Memorandum

29 May 2018

To	Department of the Environment		
Copy to	Pamela Morales		
From	Chrisjan Joubert	Tel	[REDACTED]
Subject	Comments on NBP reply	Job no.	2316318

Graph 6: Schematic of NBP OSMS Treatment System for Stage 3

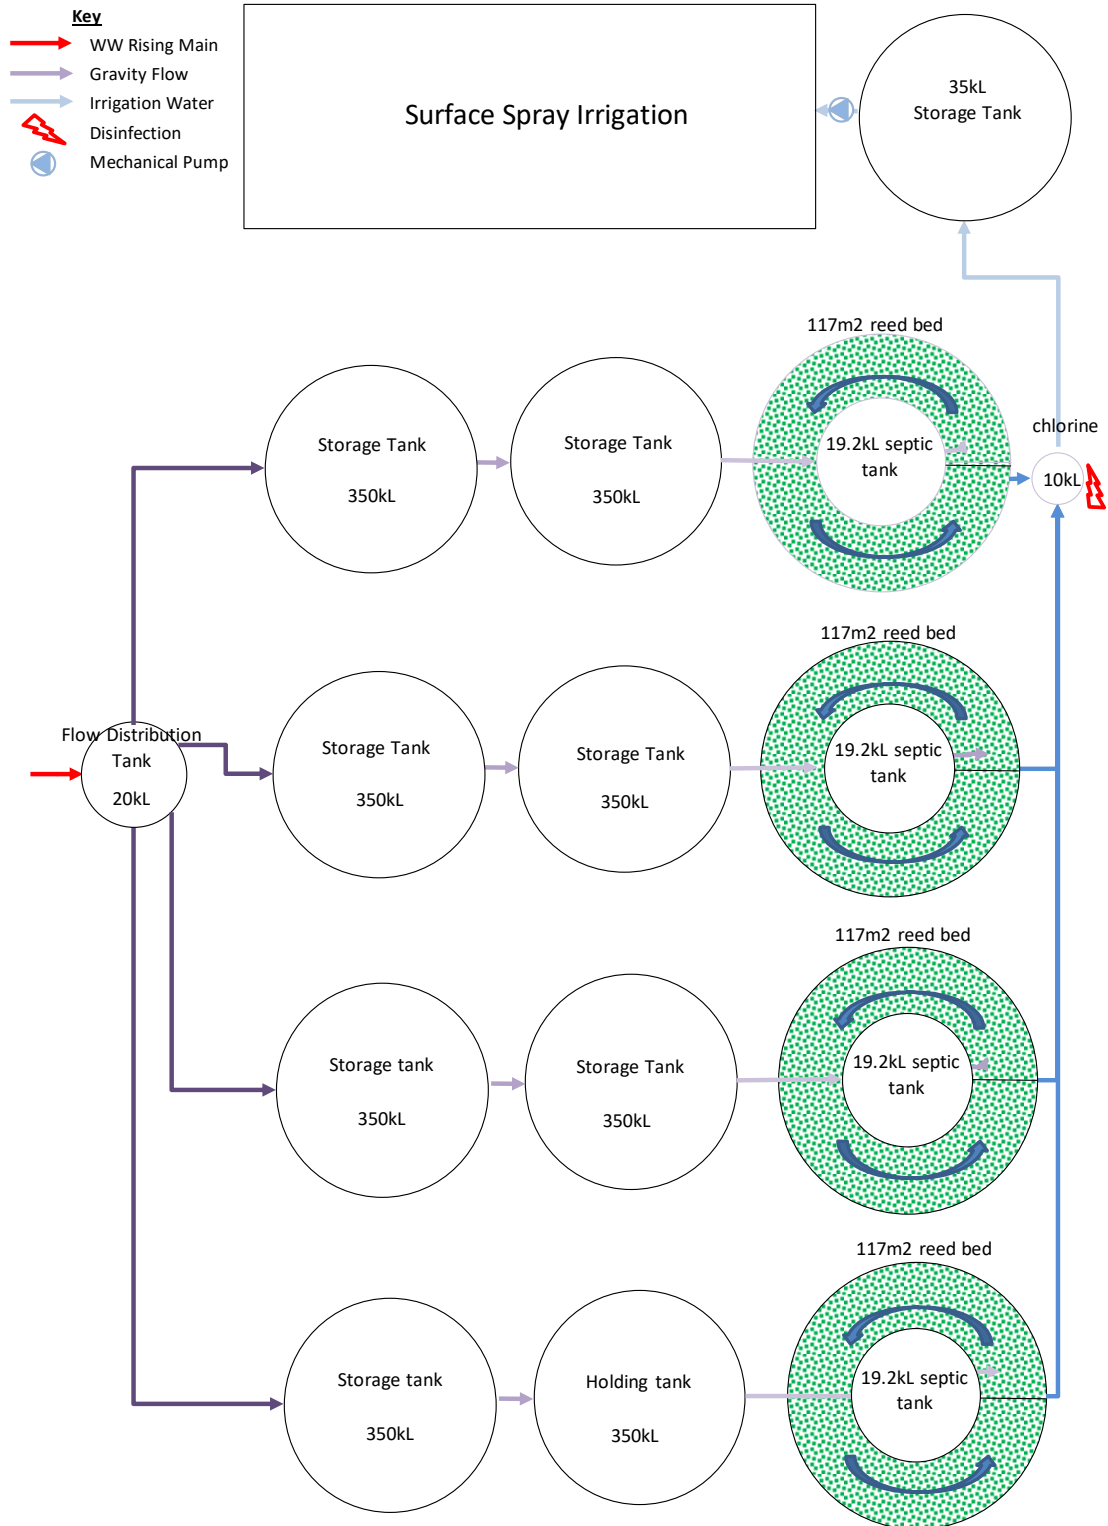
- 7G Not accepted.
- 8G W&A's modelling seems incorrect
- 9G Limited detention time and treatment capacity as proposed. High risk of environmental contamination

- 11G Proposed design does not allow for wet weather storage, hold/test/quality control of treated effluent prior to discharge.
- 12G No further comments

- Low waste water treatment level proposed;
- Risk of environmental contamination
- Undersized treatment system proposed. Footprint likely to increase for treatment and storage. Impact on sensitive high-lying environmental habitat.
- High risk of environmental contamination by waste water discharge into flood-prone, high water table irrigation area connected to waterway by means of surface drains.
